**Your Ref: 2026/0357
Our Ref: B/01618**

Chevara, 179 Sackup Lane, Darton, Barnsley – (BARNs) Demolition of existing dwelling and erection of 1 detached dwelling and garage (Custom/self build)

Client: Ms B Cook	
Project: 179 Sackup Lane Darton Barnsley, S75 5AU	
Drawing: Proposed Site Layout	
Date: Apr 2026	Scale: 1:200 @ A3
Drawing No: 2518/110	Rev:

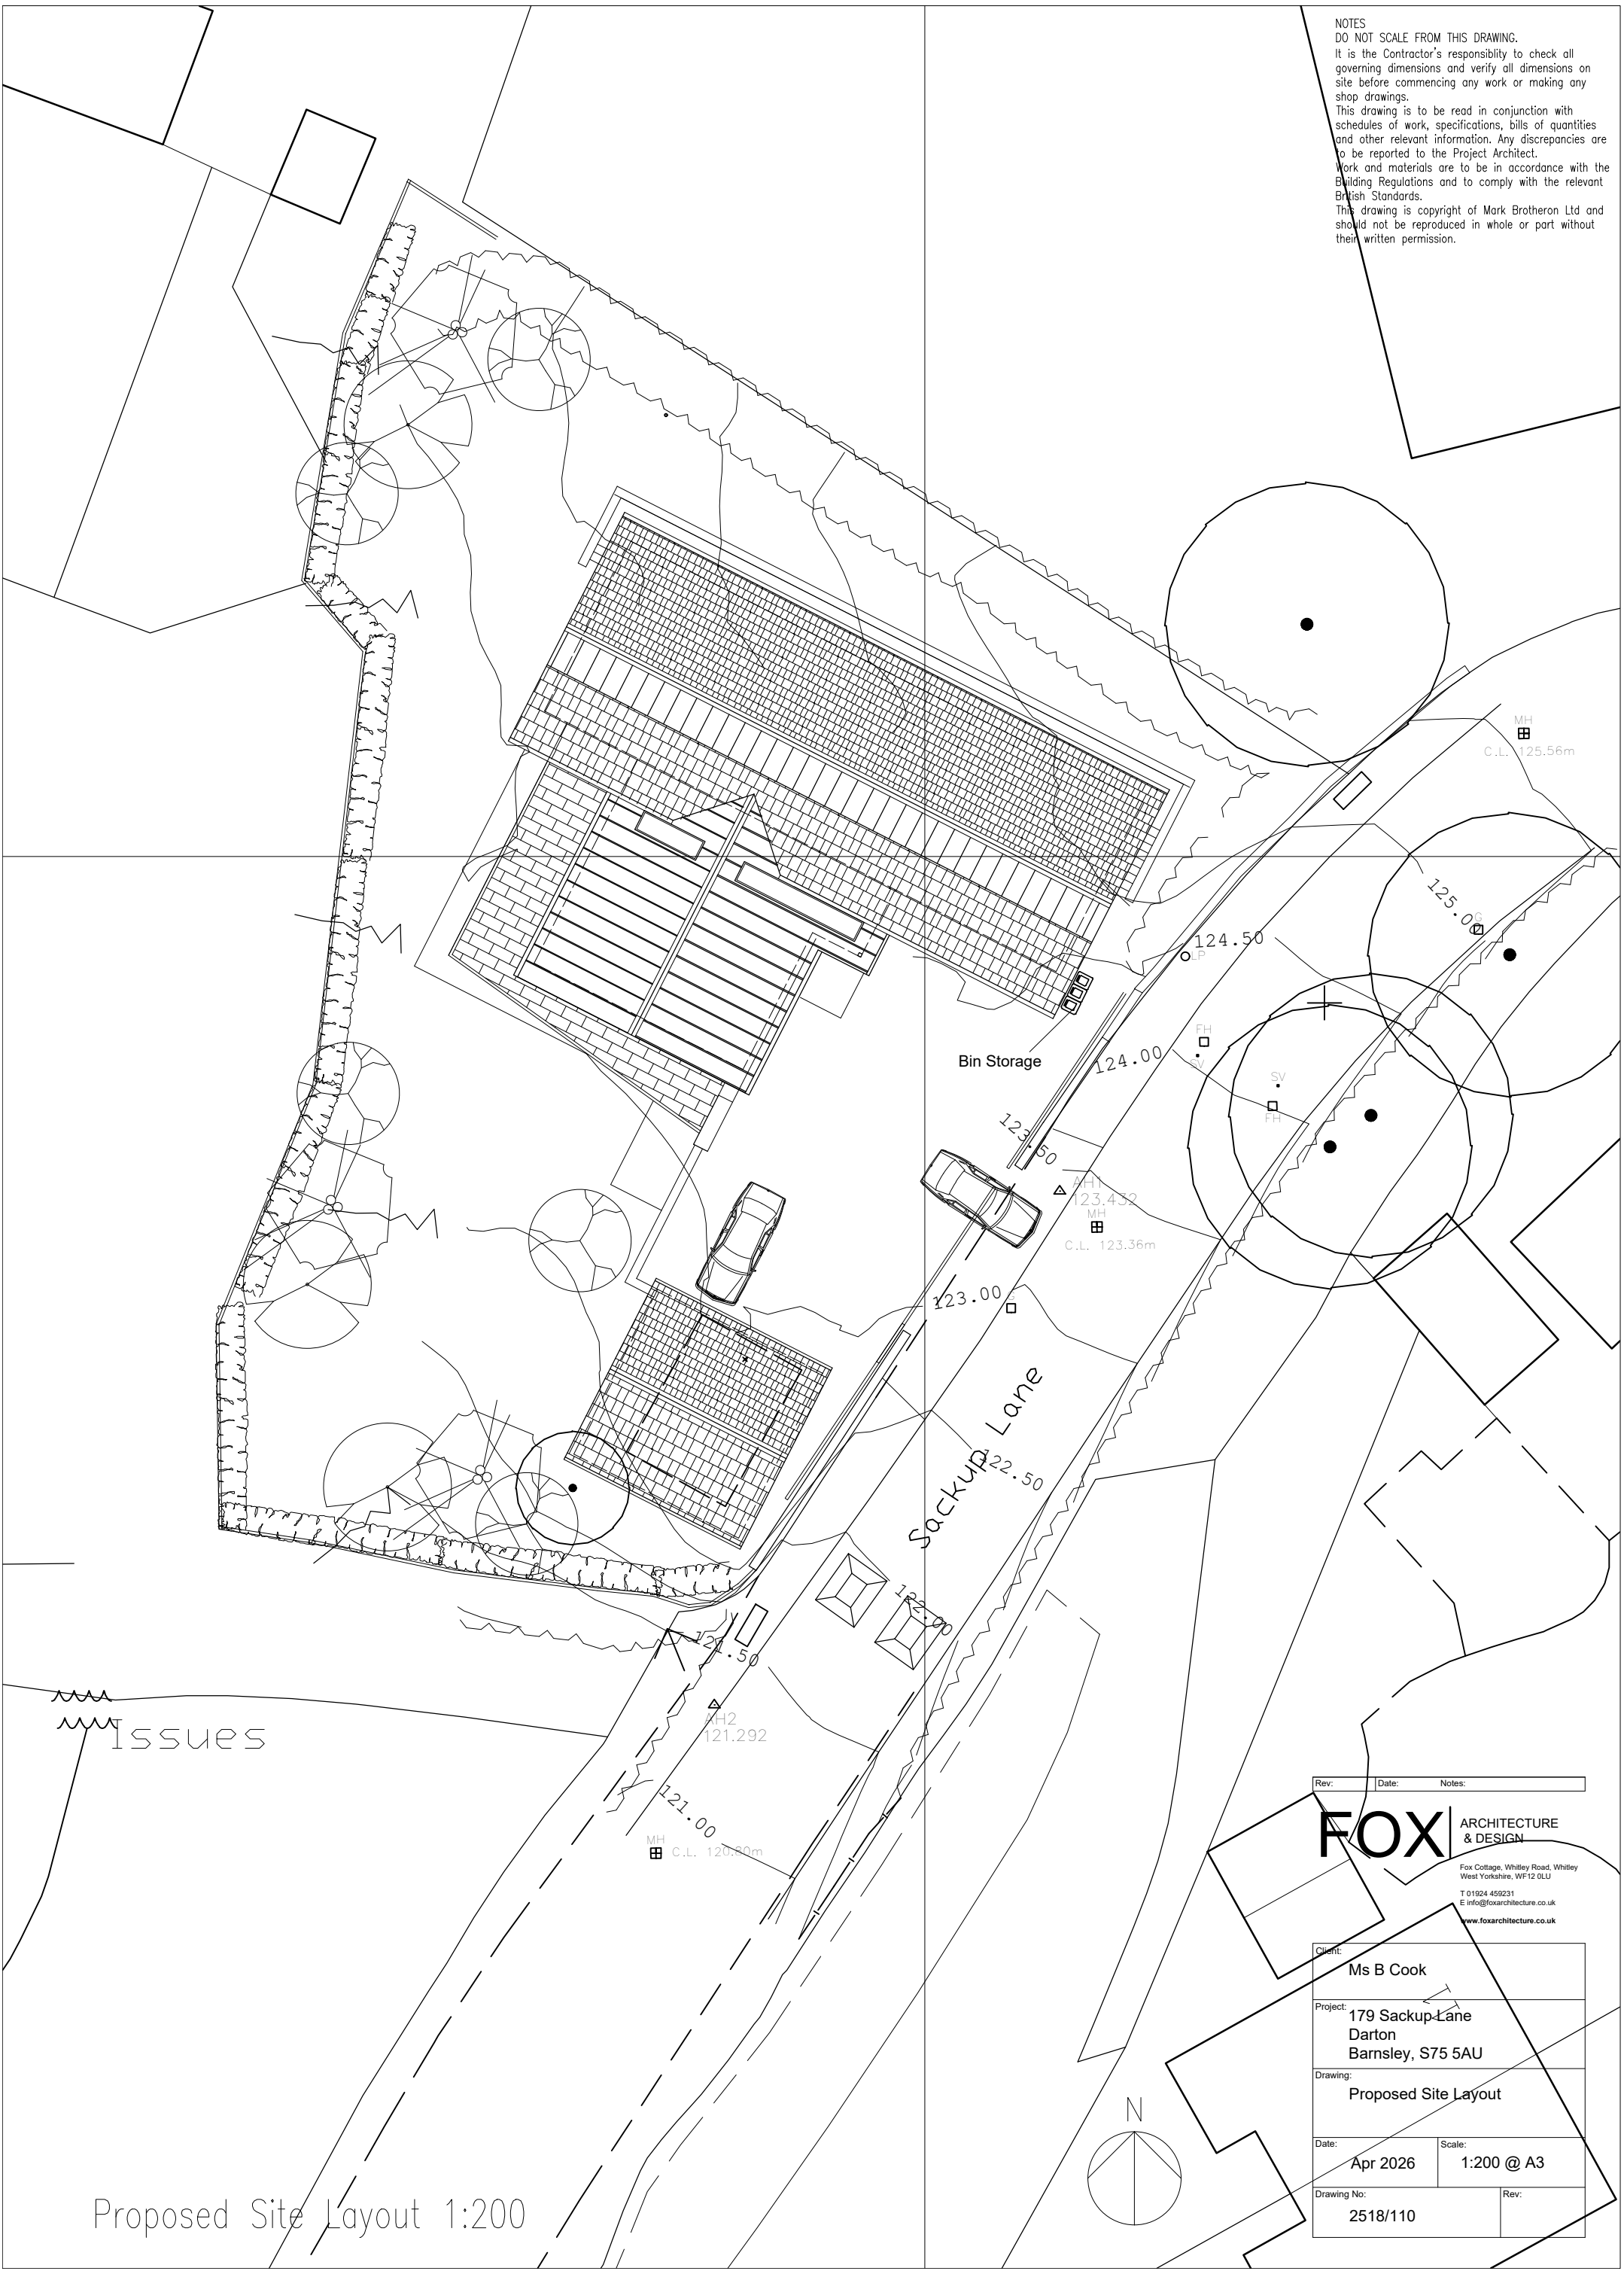
Yorkshire Water objects to the application due to lack of submitted proposed drainage proposals.

Development of the site should take place with separate systems for foul and surface water drainage. The separate systems should extend to the points of discharge to be agreed.

There is a culverted watercourse that runs through the site – this would appear to be the ideal means of surface water disposal.

As a last resort, and upon receipt of satisfactory evidence to confirm the reasons for rejection of other methods of surface water disposal, curtilage surface water may discharge to public sewer. Surface water discharges to the public sewer must have a minimum of 30% reduction based on the existing peak discharge rate during a 1 in 1 year storm event.

The developer will be required to provide evidence of existing positive drainage to a public sewer from the site to the satisfaction of Yorkshire Water and the Local Planning Authority by means of physical investigation. On-site attenuation, taking into account climate change, will be required before any discharge to the public sewer network is permitted.
